1.1.1 Velocity Transport Planning (VTP) has been appointed by Firethorn Trust (the Applicant) to provide highways and transport planning advice for an outline planning application relating to the development of up to 530 dwellings on land which forms part of the North West Bicester Eco Town development (Policy Bicester 1 of the adopted CDC Local Plan), located in Oxfordshire.

1.1.2 The Proposed Development description for the outline planning application, planning reference: 21/01630/OUT, is as follows:

TECHNICAL NOTE: RESPONSE TO OCC COMMENTS

DRAWING TITLE  
**ELMSBROOK SPINE  
ROAD ASSESSMENT**

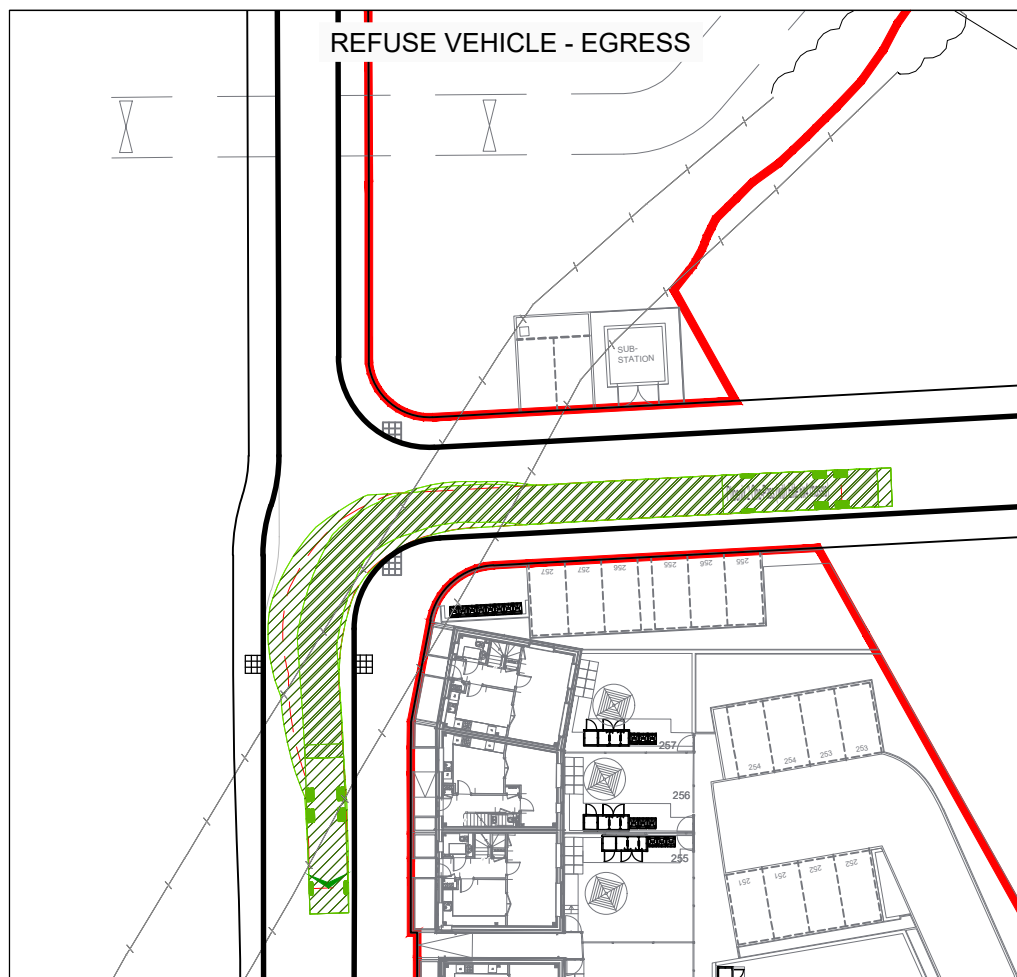
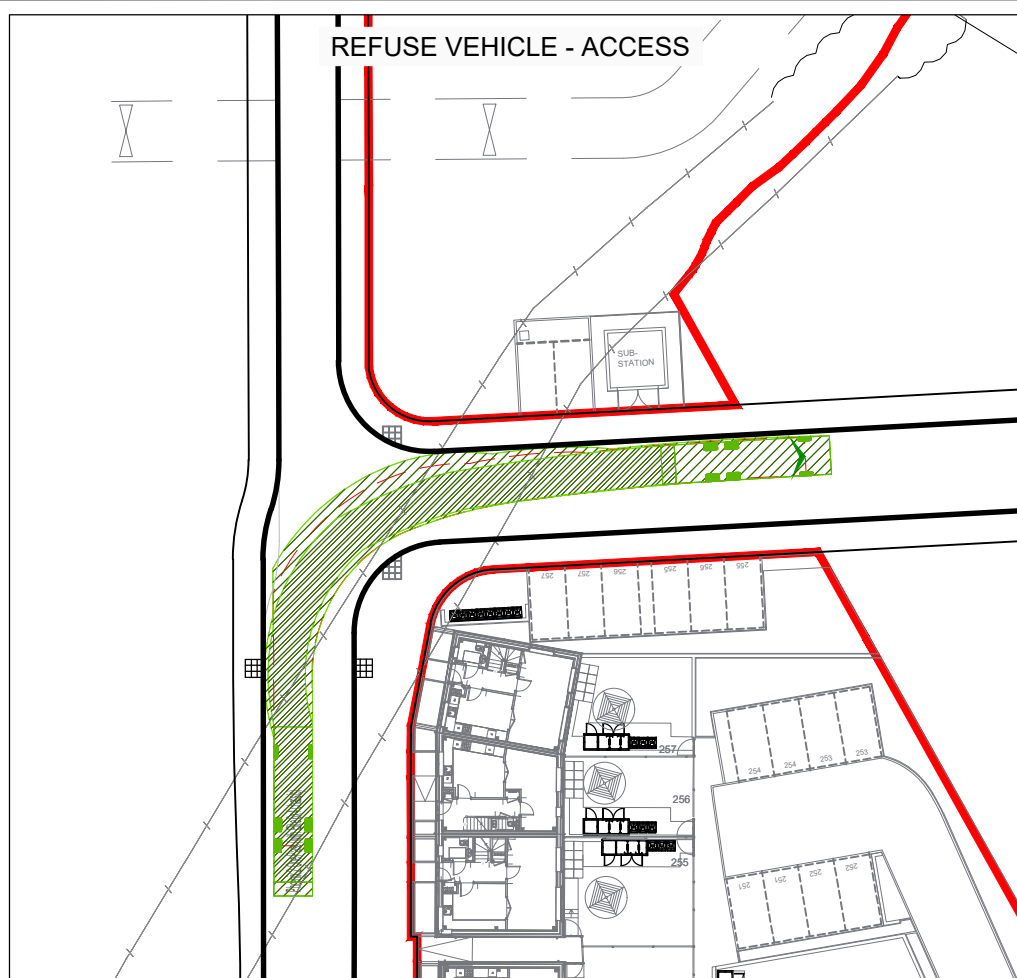
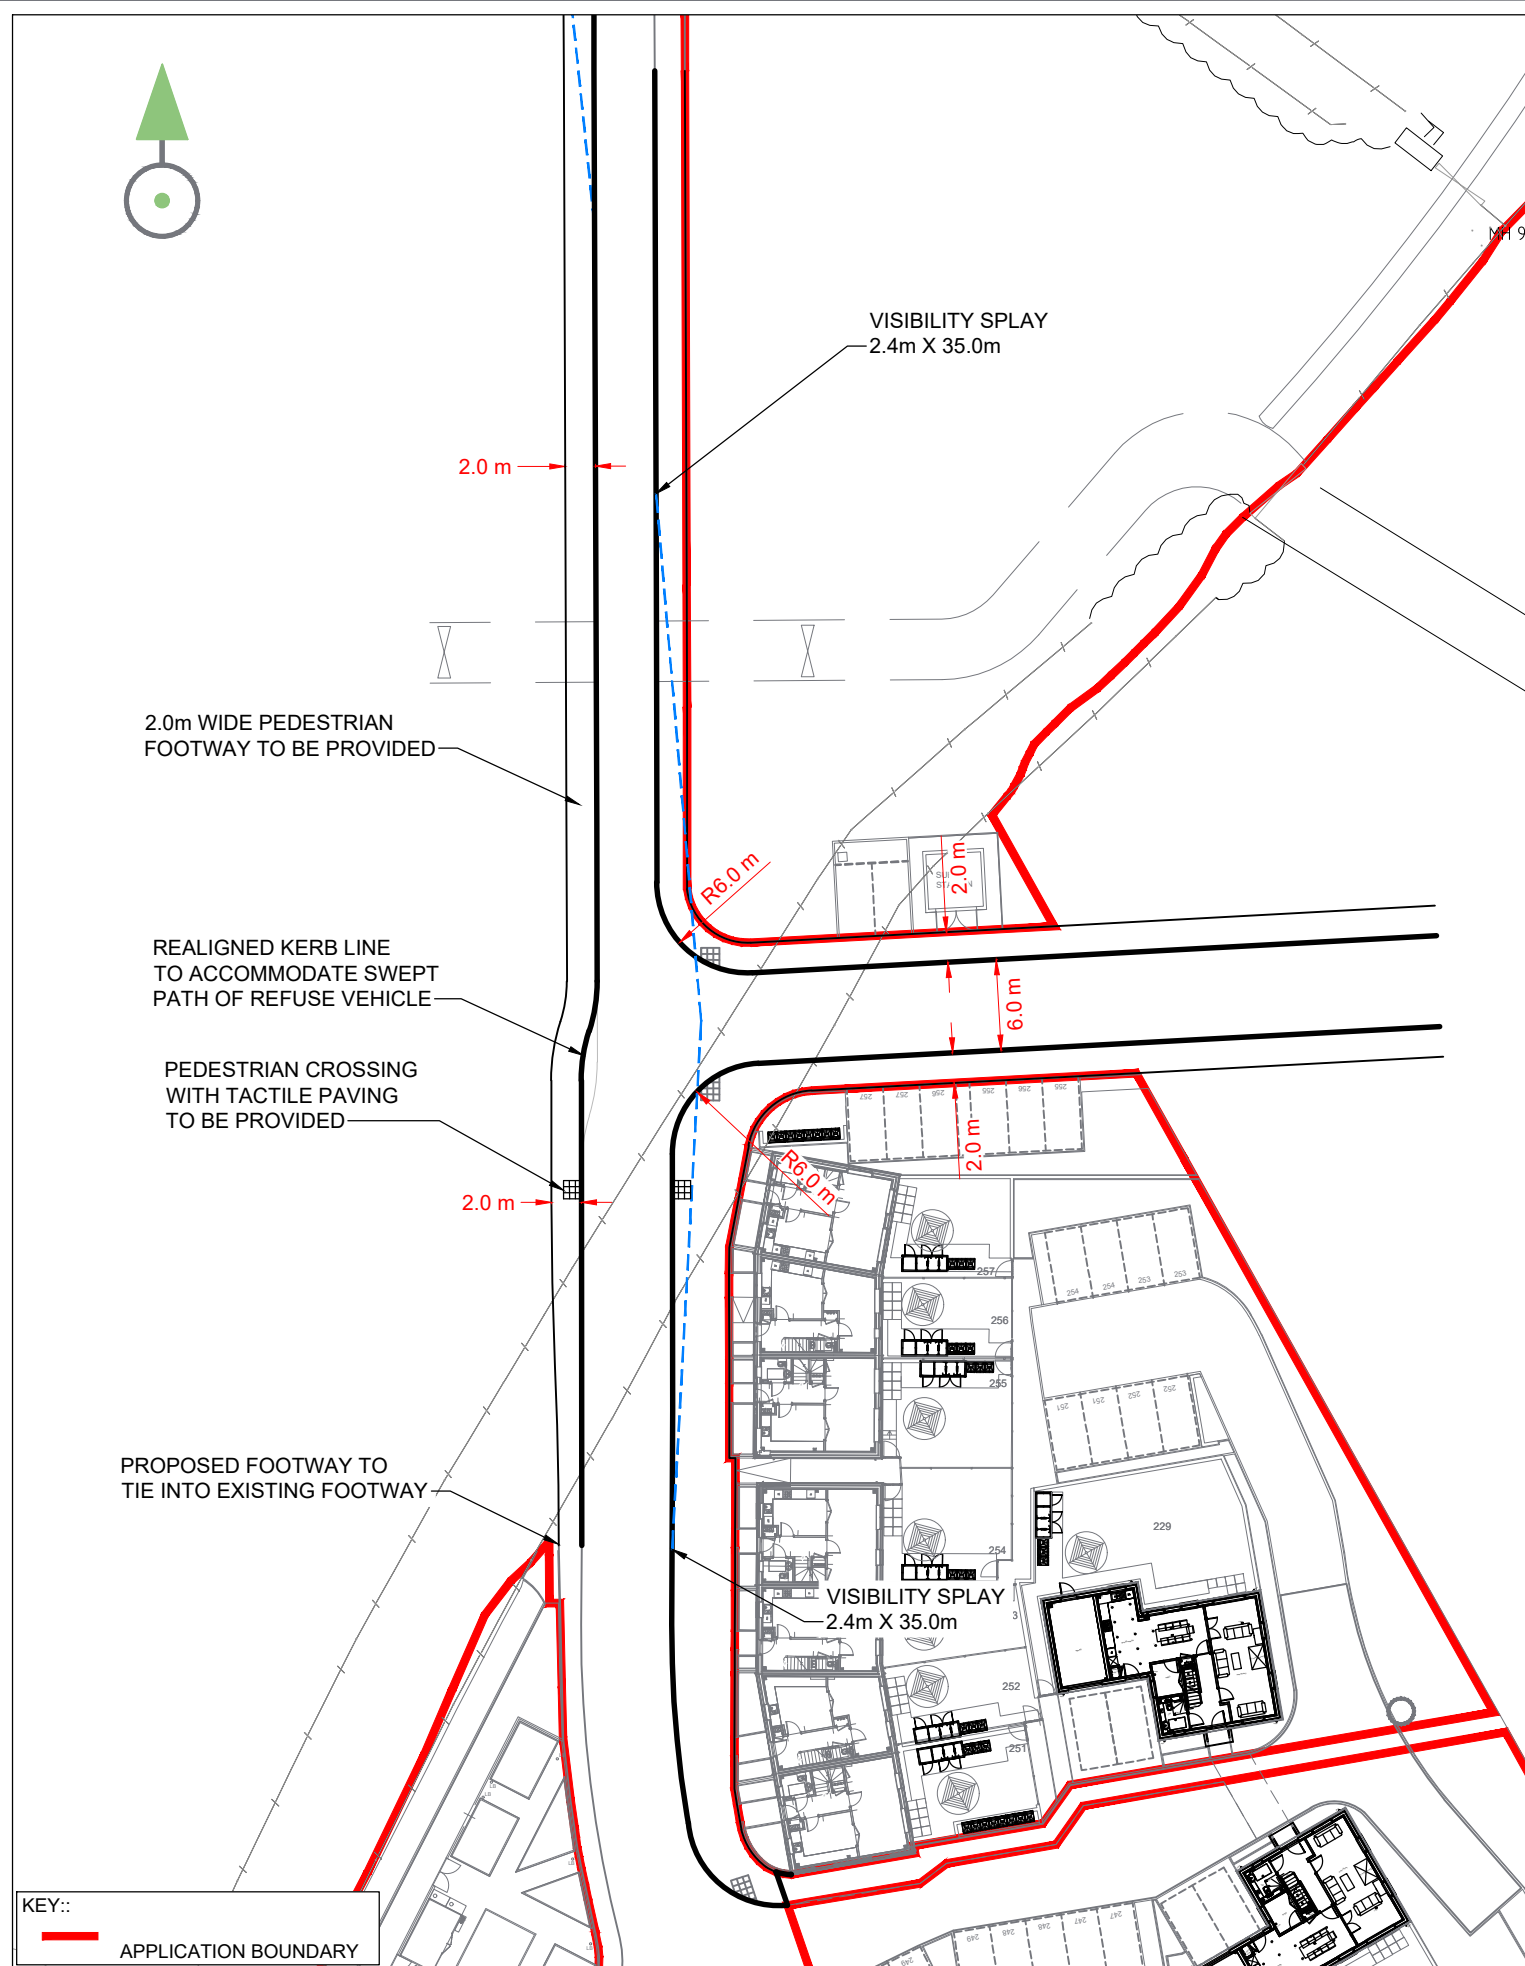
- 2.4.2 However, following further discussion with OCC, it is evident that there is still a concern regarding the suitability of the narrow section of the Elmsbrook Spine Road to the north of the Gagle Brook Primary School, where the existing width of the road is identified as being 4.1m in places.

- 2.4.3 VTP Drawing 4600-1100-T-070 Rev A – Elmsbrook Spine Road Assessment (a copy of which is included at **ATTACHMENT B**) has been prepared to identify the existing dimensions along this section of the Spine Road, and it is clear that there are a number of locations where the existing width is reduced to as little as 4.1m. In addition, this plan shows that there are currently a total of 52 dwellings, 99 car parking spaces, and 14 garages associated with the existing Elmsbrook scheme currently accessed via this section of the Elmsbrook Spine Road. In addition to the residential dwellings, access is currently accommodated for refuse vehicles, buses using the Elmsbrook Spine Road, and any other heavy goods vehicle activity that has been permitted for the Elmsbrook development (i.e. emergency vehicles, removals vans, deliveries, etc).

- 2.4.7 In order to establish if the carriageway width of 4.1m is suitable to accommodate two-way traffic flows of as much as 140 cars and a maximum of say 4 HGV movements (2 one-way bus movements and 1 two-way refuse vehicle movement), consideration has been given to the information presented at Table 4-1 of TN004, which identified the capacity of carriageways of varying widths, as set out in DMRB TA 77/99. For

clarity, a 4.1m carriageway was identified as being suitable to accommodate a maximum of 482 one-way flows (60% of two-way flow) and 804 two-way flows over an hour.

- 2.4.8 As the evidence presented in **Table 2-1** identifies that a maximum of 140 two-way cars + 4 two-way HGV movements (assumed) would be expected when the full Firethorn Development is occupied and shares the use of this stretch of the Elmsbrook Spine Road with the existing Elmsbrook development, it is clear that a narrow carriageway width of 4.1m for limited sections of the Elmsbrook Spine Road to the north of the Gagle Brook Primary School, would be suitable.

REVISION DETAILS		
DRAWING NO.		
4600-1100-T-011		
DRAWN	APPROVED	DATE
EP	MP	JAN 21
SCALE		REV
AS SHOWN @ A3		F

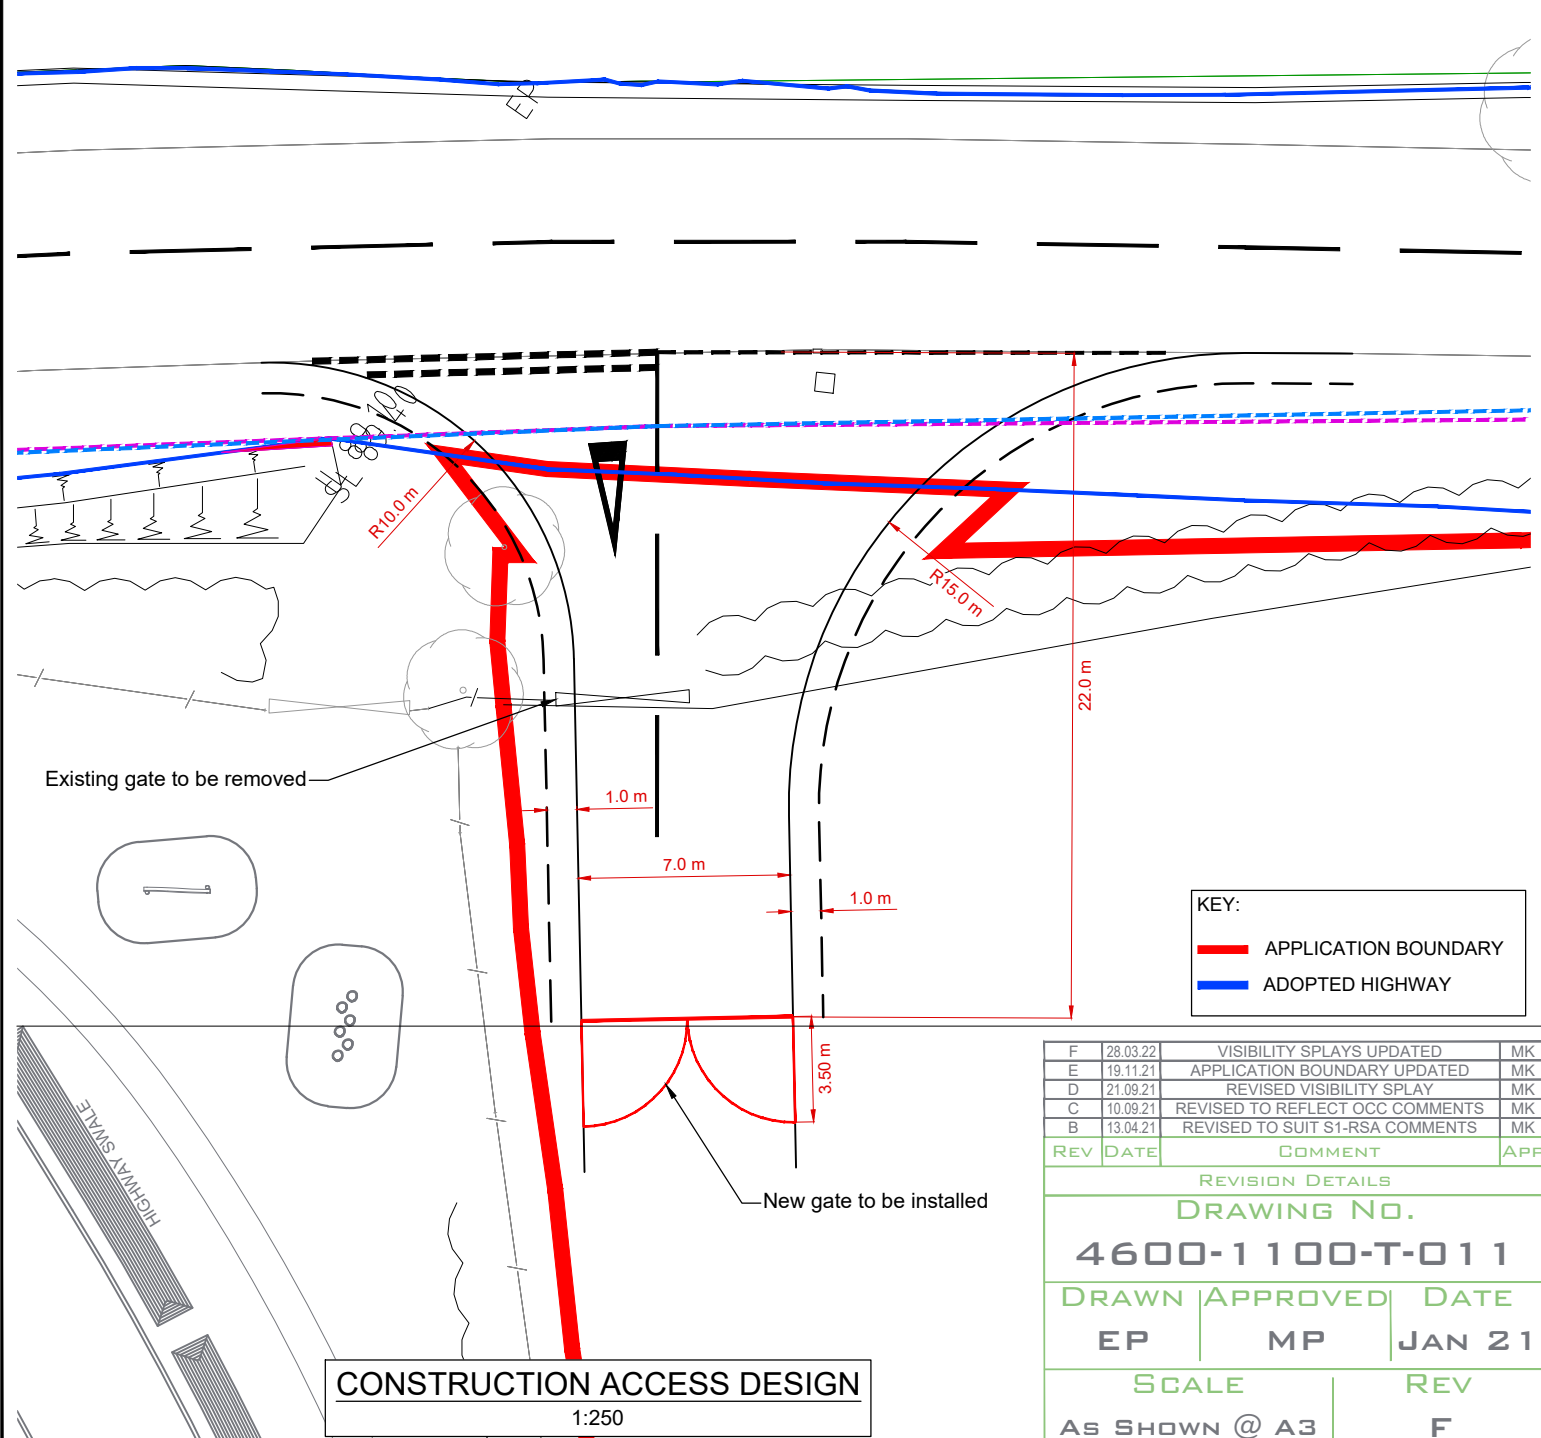
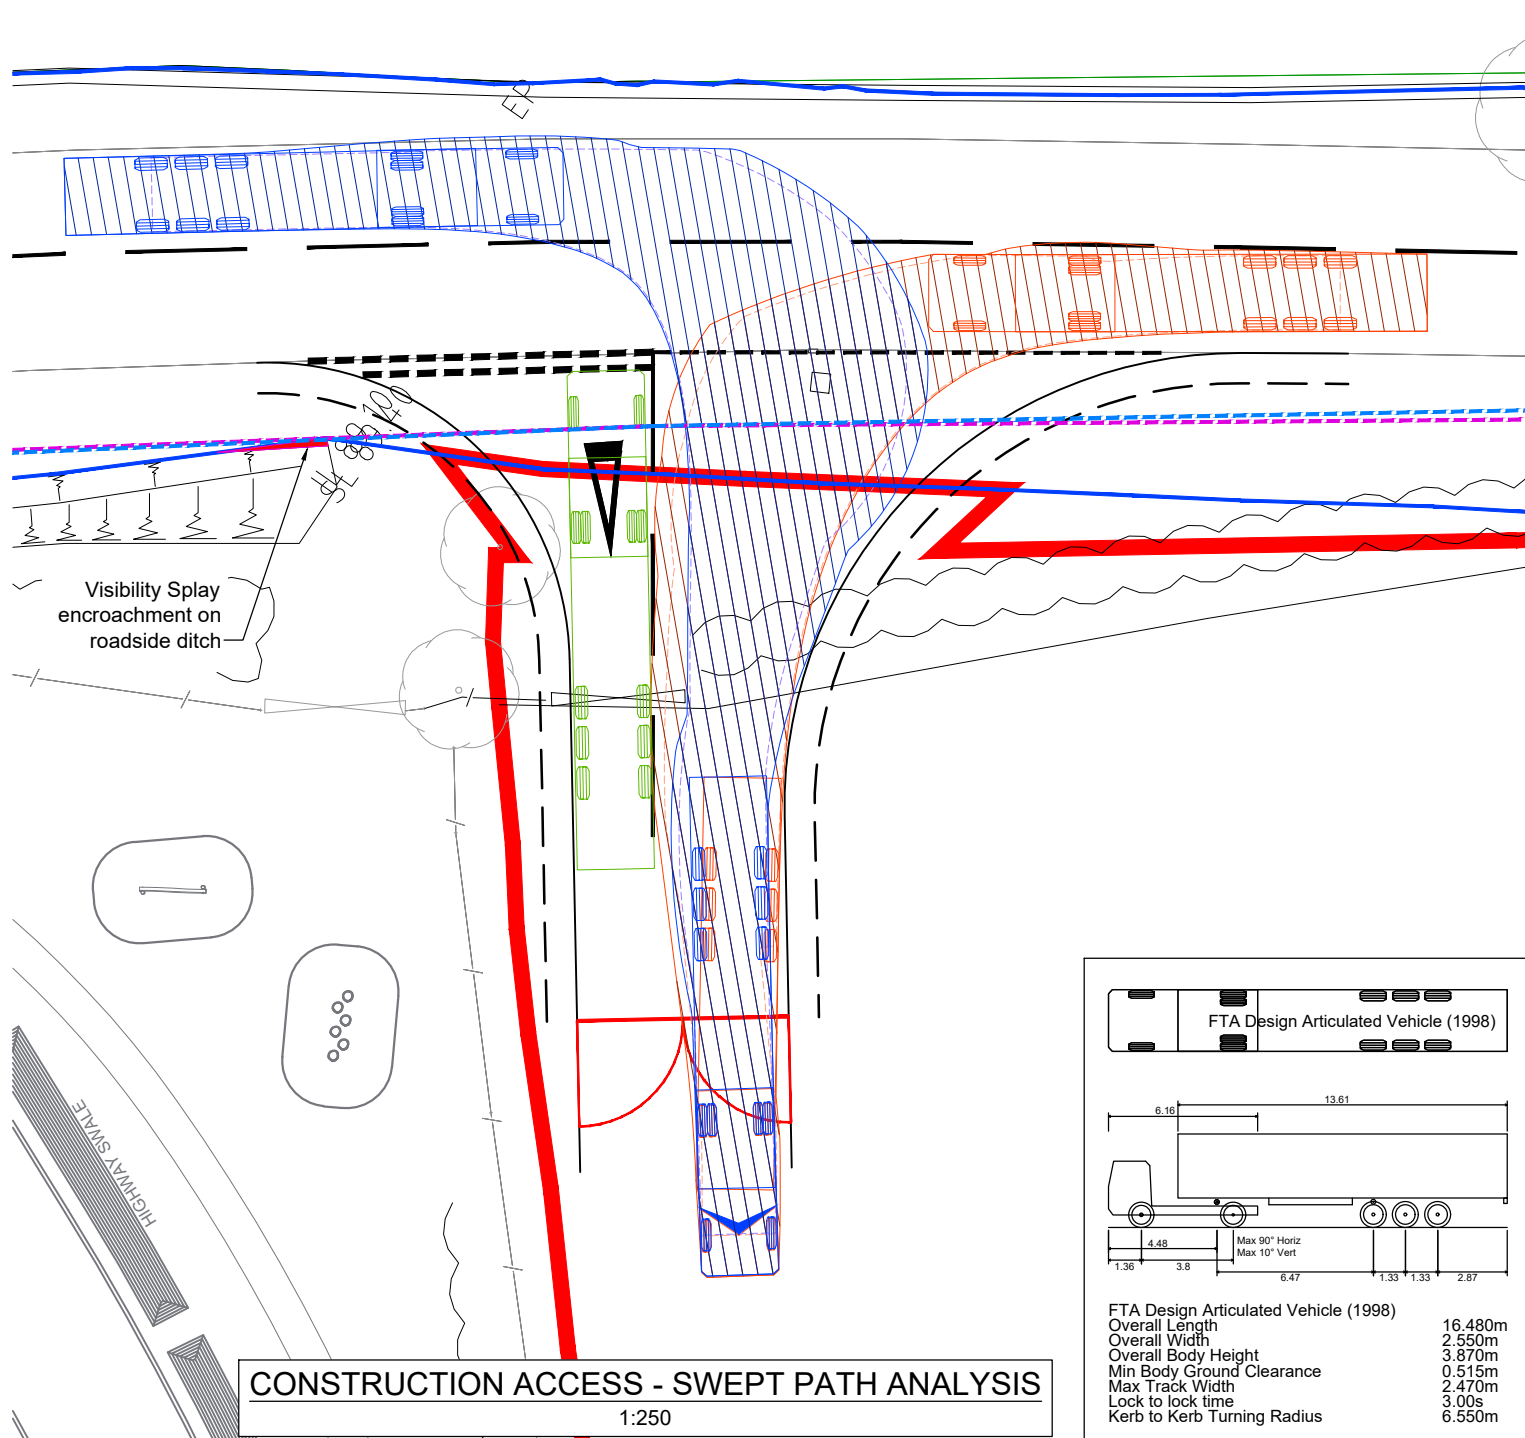
3.3.1 It is acknowledged that the existing speed limit along the B4100 in the vicinity of the proposed temporary construction access to the eastern parcel is 40mph. In accordance with DMRB, this would require a junction visibility splay of 2.4m x 90.0m. VTP Drawing 4600-1100-T-011 Rev F, a copy of which is included at **ATTACHMENT B**, identifies that this visibility can be achieved towards the east, but due to the existing drainage ditch located to the immediate west of the proposed temporary access, the visibility splay is compromised.

3.3.2 As set out in the response from OCC, should the speed limit along this stretch of the B4100 be reduced to 30mph, this would require visibility splays of 2.4m x 70.0m, which are shown to be achievable on the updated Proposed Construction Access plan.
